From: Hebe Smith
Sent: 21 January 2025 10:43
To: Planning.Responses
Subject: FW: Application AW/299/24/HH - 8 Cherry Close
Attachments: Prop FF Plan 1.pdf; Prop Front Side Elevations 1.pdf; Prop Rear Side Elevations 1.pdf; Site Plan 1.pdf; Action Sheet v4 Electronic Version AW-299.docx

Subject: Application AW/299/24/HH - 8 Cherry Close

PROPOSED ELEVATIONS

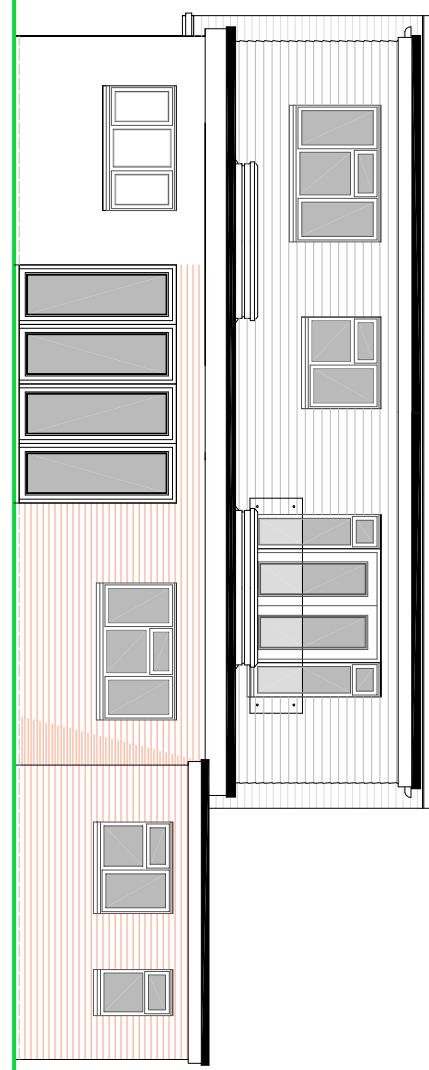
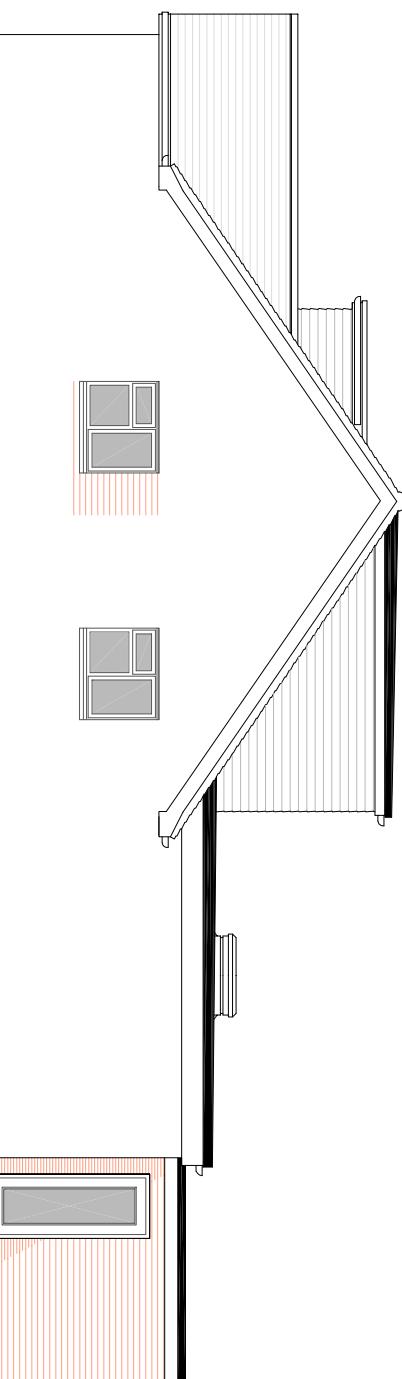
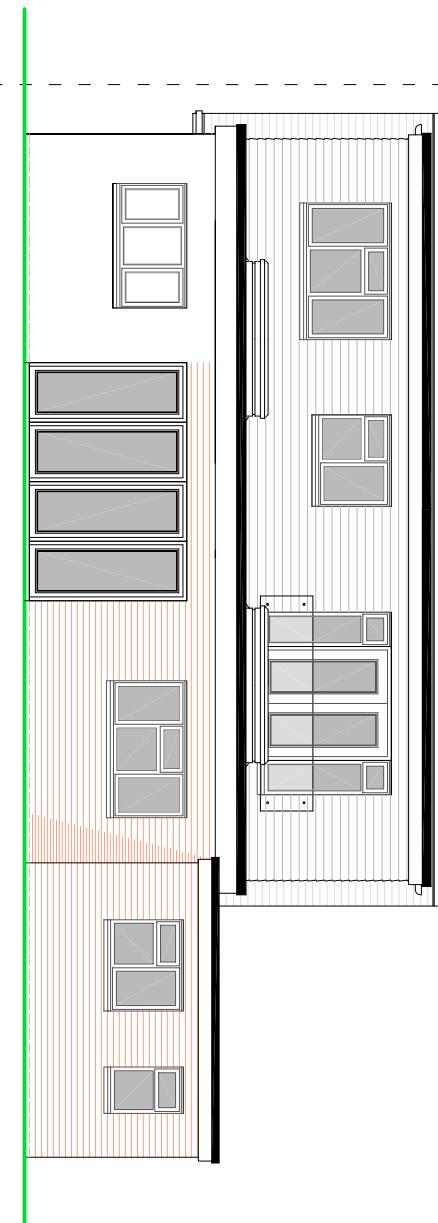
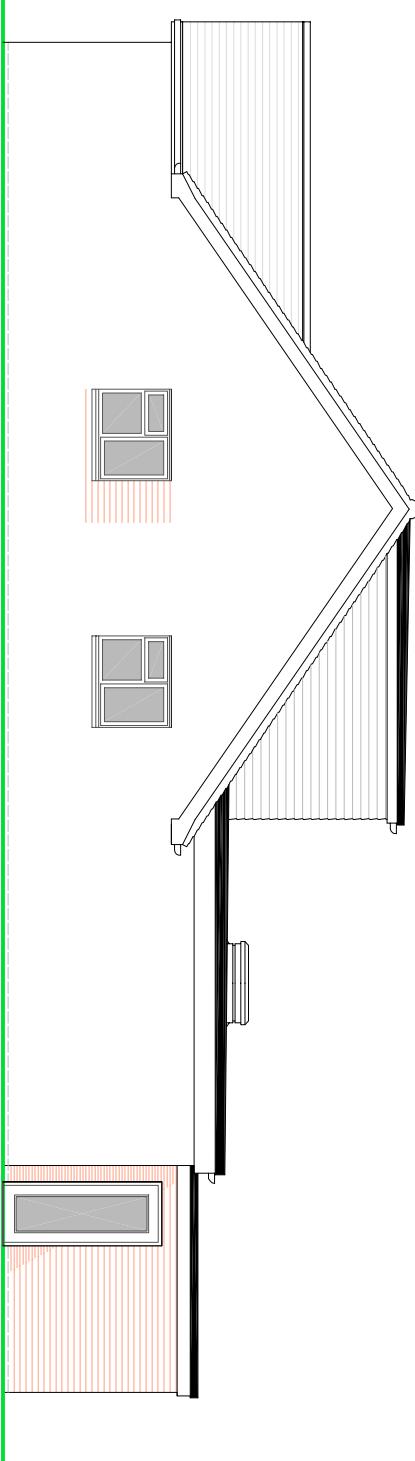
I have had a look at the plans and visited the site for your application AW/299/24/HH. I have some concerns about the proposed front dormer, given that front dormers are not a feature of the street scene. There is also some conflict with policy D DM4 and the Arun Design Guide. Would it be possible to remove this element from the design?

In response, I have been in touch with the applicants who have decided reluctantly to remove the front facing dormer. Accordingly, I attach a copy of revised first floor plan and elevations.
